Response to Education SEPP Design Quality Principles

Response to SDRP Feedback

PROJECT: Hastings Secondary College upgrade
RE: SDRP SESSION 70 – 17.02.2021 (first review)

HSPM

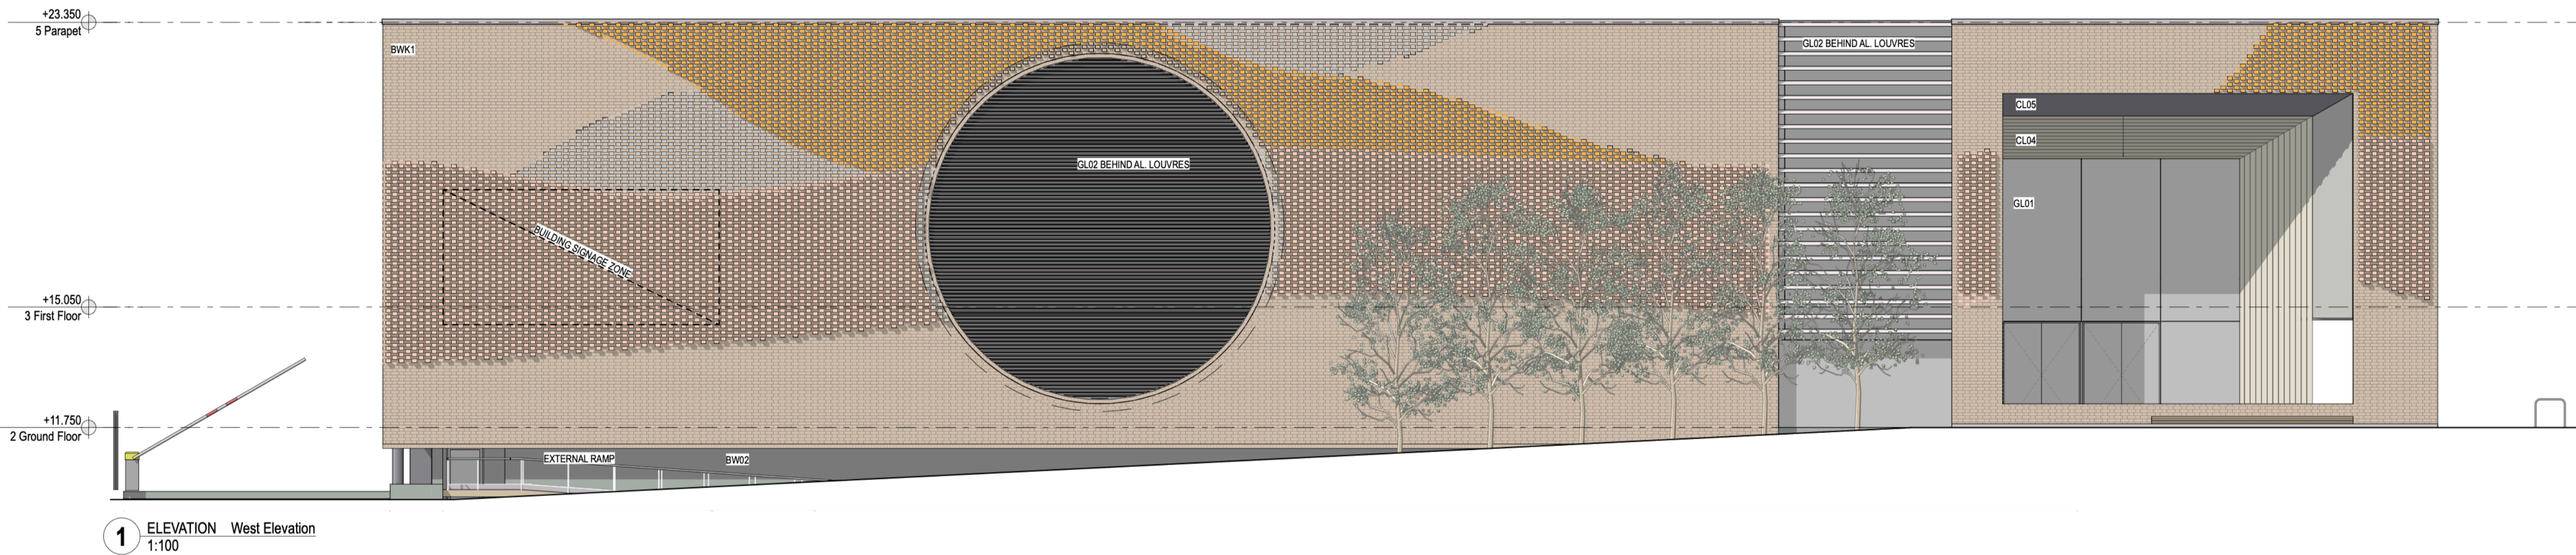
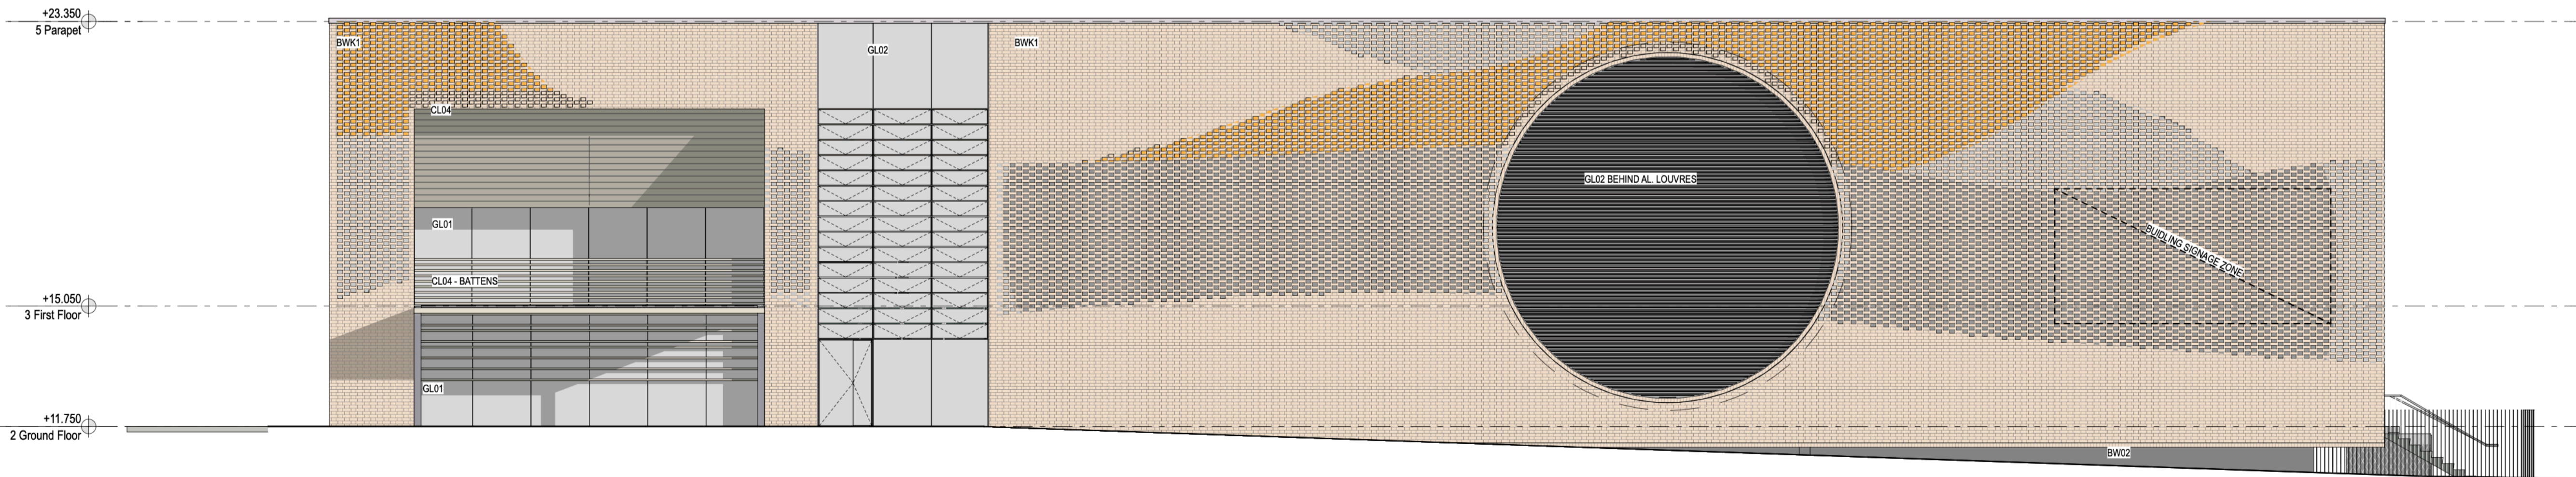
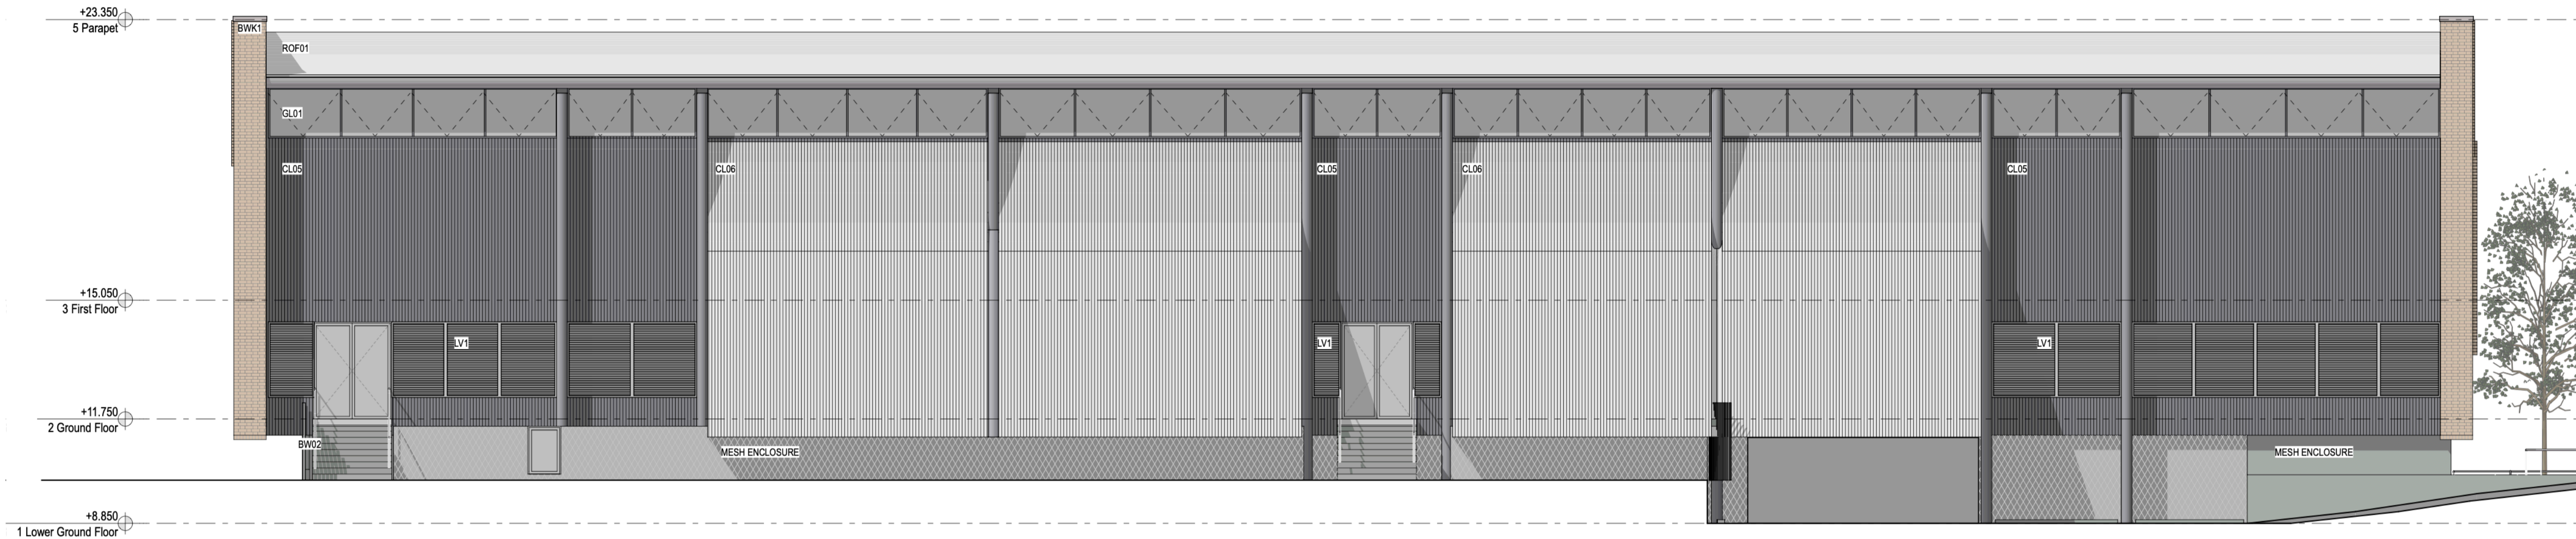
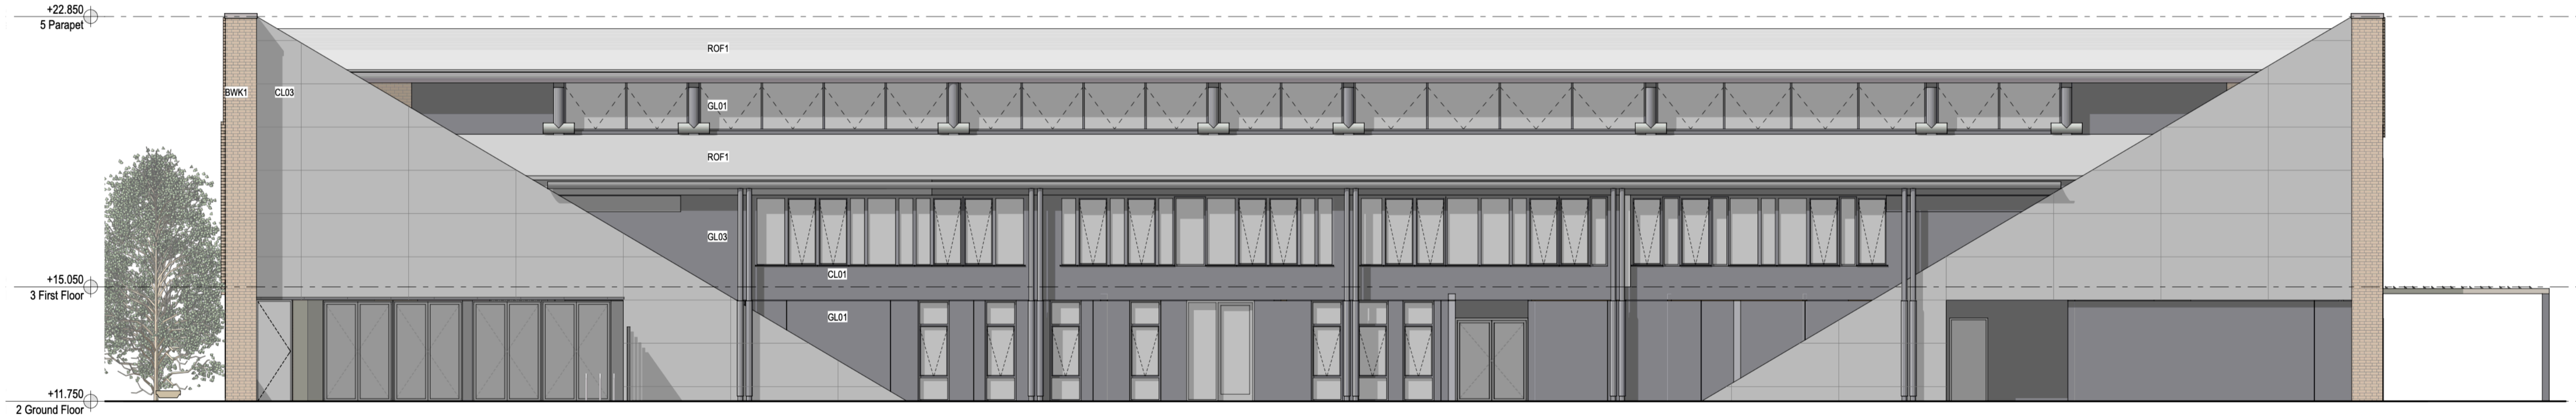
3.4	The architectural treatment and expression of the PCYC is was difficult to understand in relation to the rest of the proposal. This significant element within both the school and the streetscape requires further development to demonstrate how it responds to its context and to the overall campus.	Geometry The bold geometry of the PCYC east and west cantilever blade walls with the large circular opening, reflects the large scale of the context and is a counterpoint to the rectilinear geometry of the College. The circle is a compelling expression of harmony and unity, embodying the values of a community focussed facility, a centre for sports. The two blade walls play with the civic scale of the site emphasising its broadness and long views both north and east. Invitation The deep set verandah on axis to Gordon Street (Oxley Highway) provides a transitional public/private space. The verandah will be lined with timber boarding and has views down Gordon Street (Oxley Highway).
